14 February, 2011

**Application No.:** Major Project Application MP 10\_0105  
**Property:** Lot 201 in DP 1101828,  
Site 2A and 3A,  
40 Walker Street, Rhodes NSW

**Proposal:** Proposed mixed residential and retail development.  
**Re:** Urban Design Review for DA for 40 Walker Street

1 ELEVATION
Walker Street Elevation
1:350

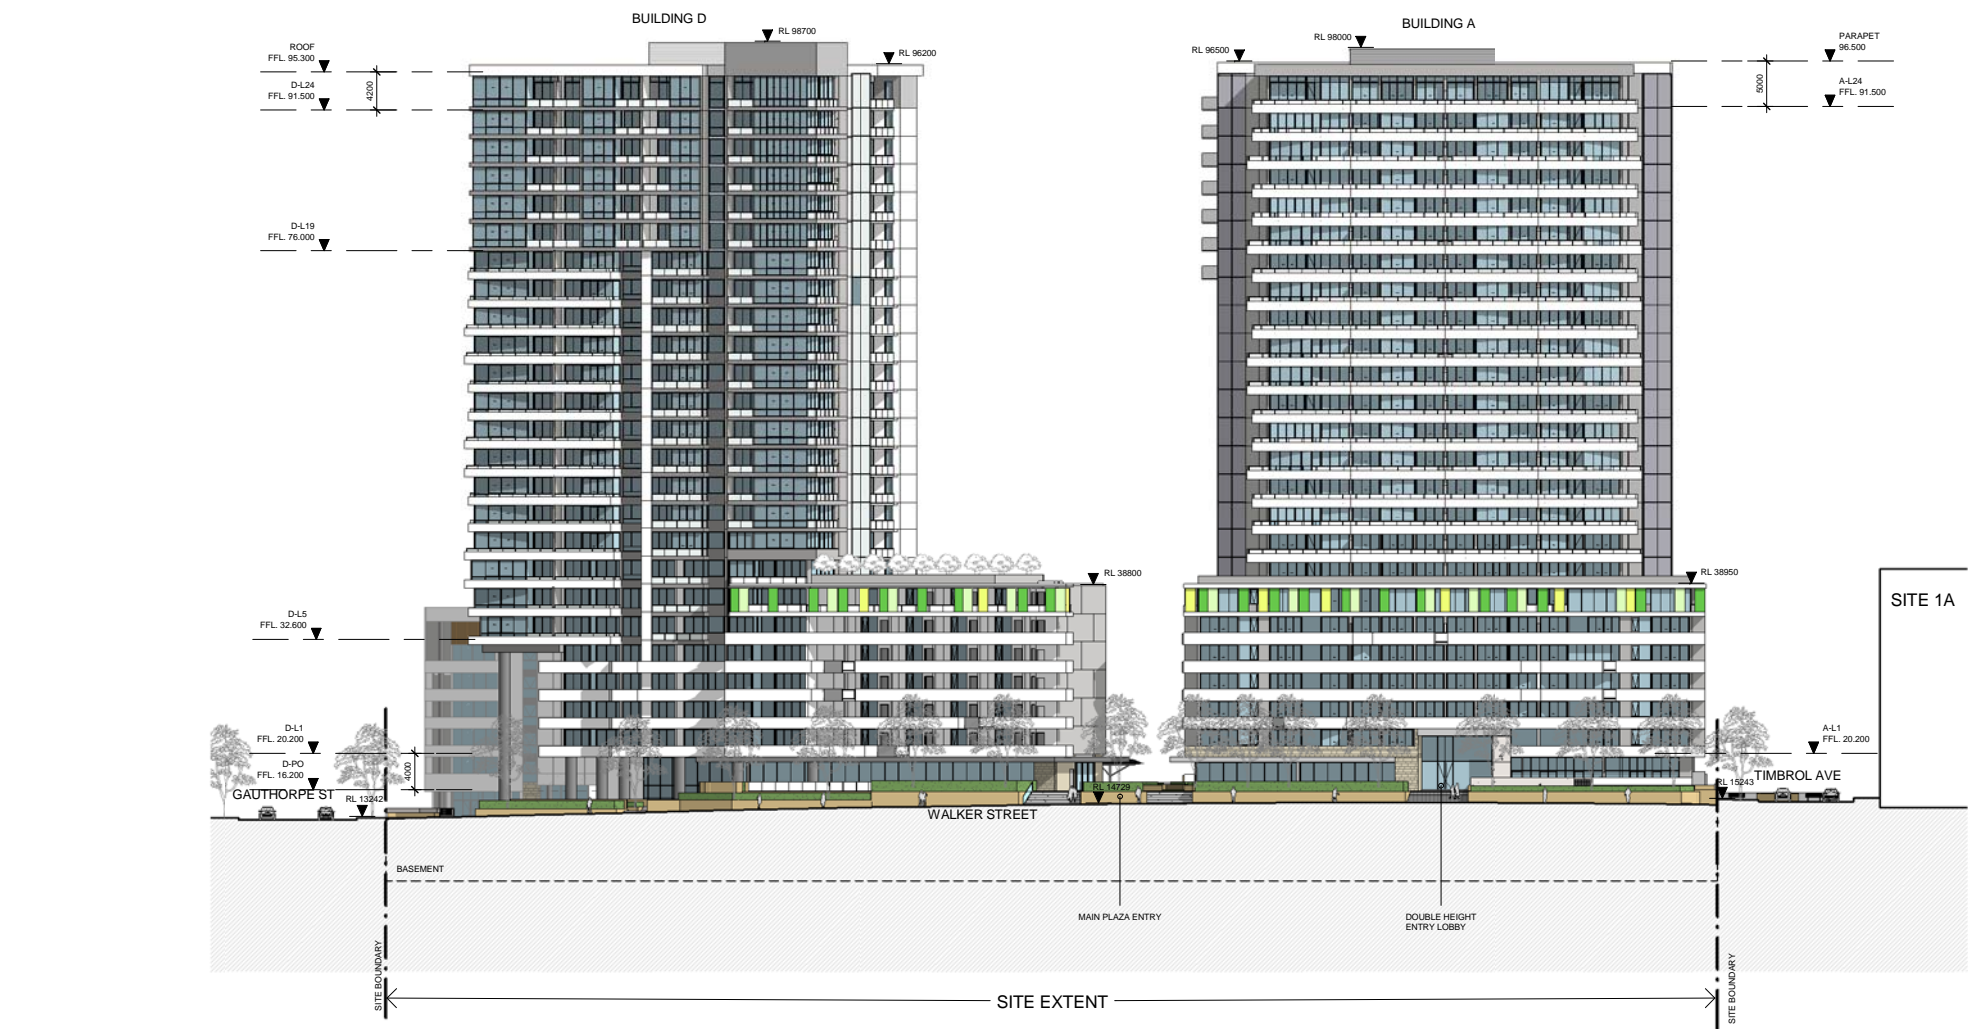
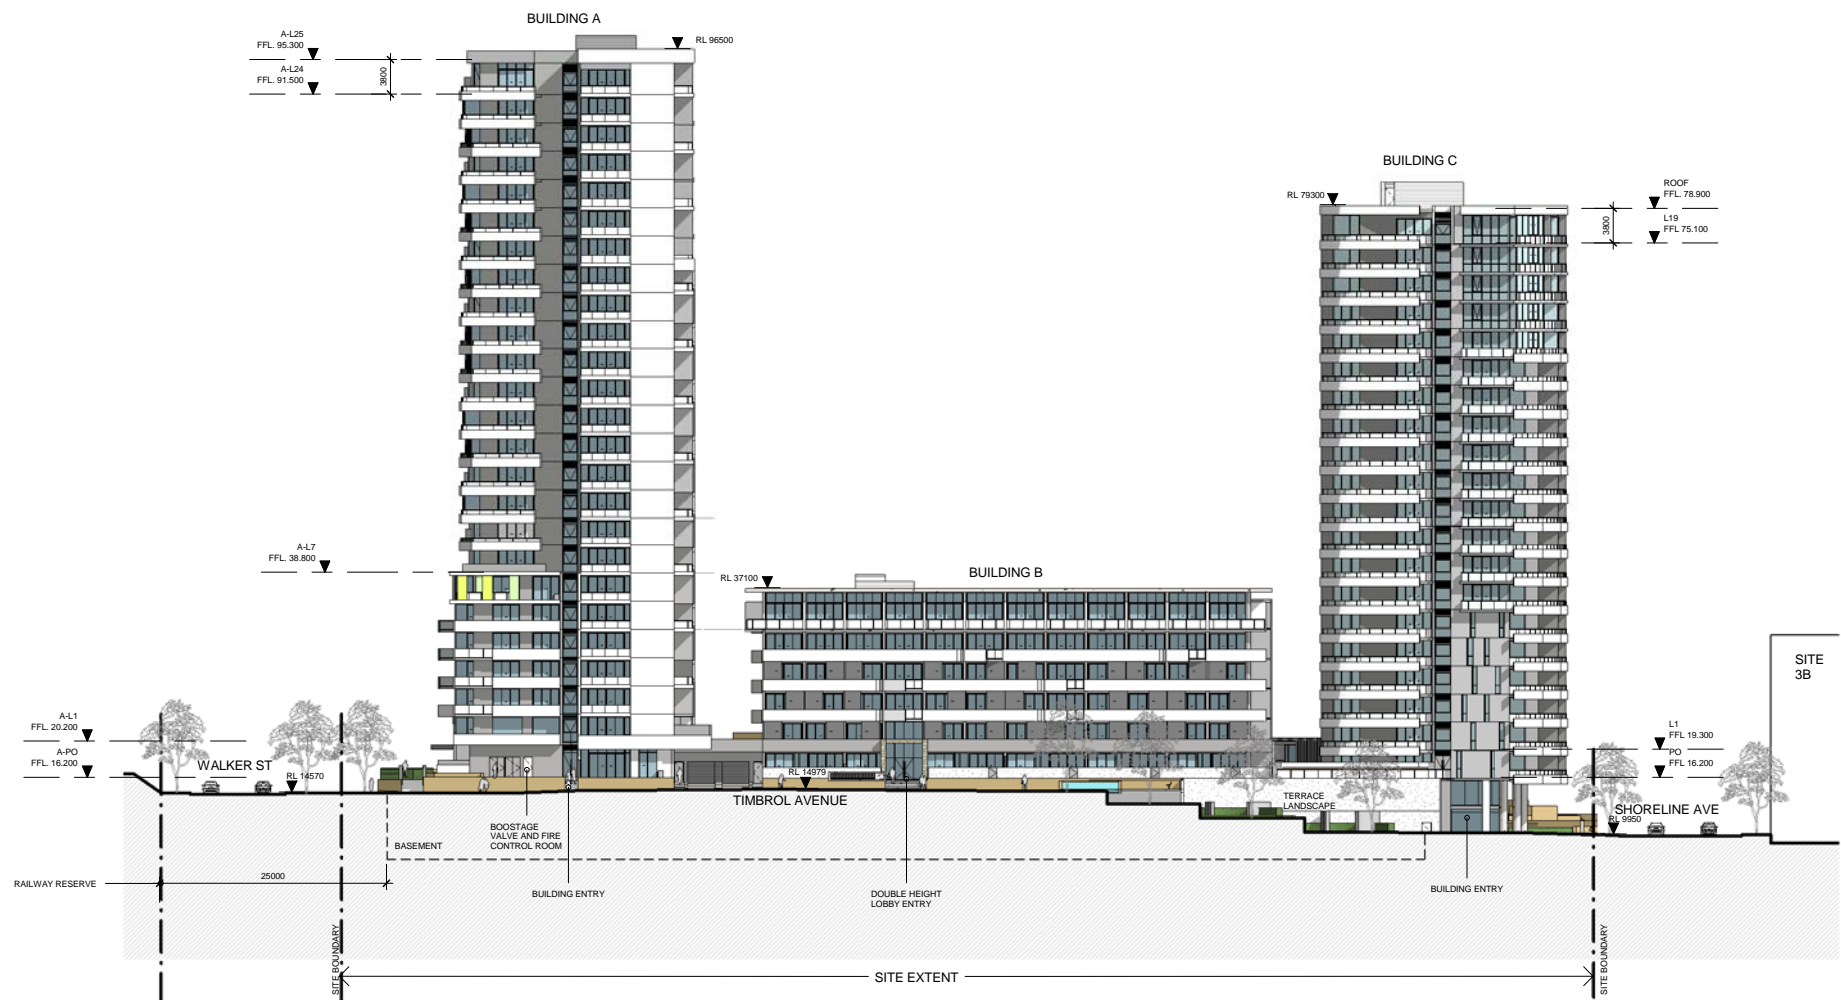
The main non-compliance to the required street setback is to the east along Walker Street. This is a result of a wrong interpretation of the DCP. The DCP diagrams (Figure 81 on page 125 and fig. 82 on page 124) show a podium level built to line within 5m from the boundary. Tower structures above the podium toward the northern end of the block should be set back 10m from the boundary. The proposal applied an overall greater setback to the podium (approximately 7-8m) with a tower structure immediately above, only slightly setback above level 7. It is possible to recognize the podium from the tower mainly because of a difference in treatment and colour to the facade above the 7<sup>th</sup> level, but not because of the mandatory setback, as required by the DCP.

From an urban design point of view this is a major non-compliance since the street wall setback (podium) to Walker Street should not exceed the requirement. The main role of the proposed 5m setback is to maintain the urban street character along the street wall, define the street edge and give emphasis to the corners of the site. The 5m setback above the podium is also necessary to mitigate the adverse impacts of wind downdrafts.

There is also a non-compliance with the street setbacks of the proposed built form to the corner of Timbrol Avenue and Walker Street. The DCP requires a 2 storey undercroft and 15m setback from the boundary to provide a small plaza on that corner. This is not taken into account in the proposed design, therefore this is not an acceptable outcome.
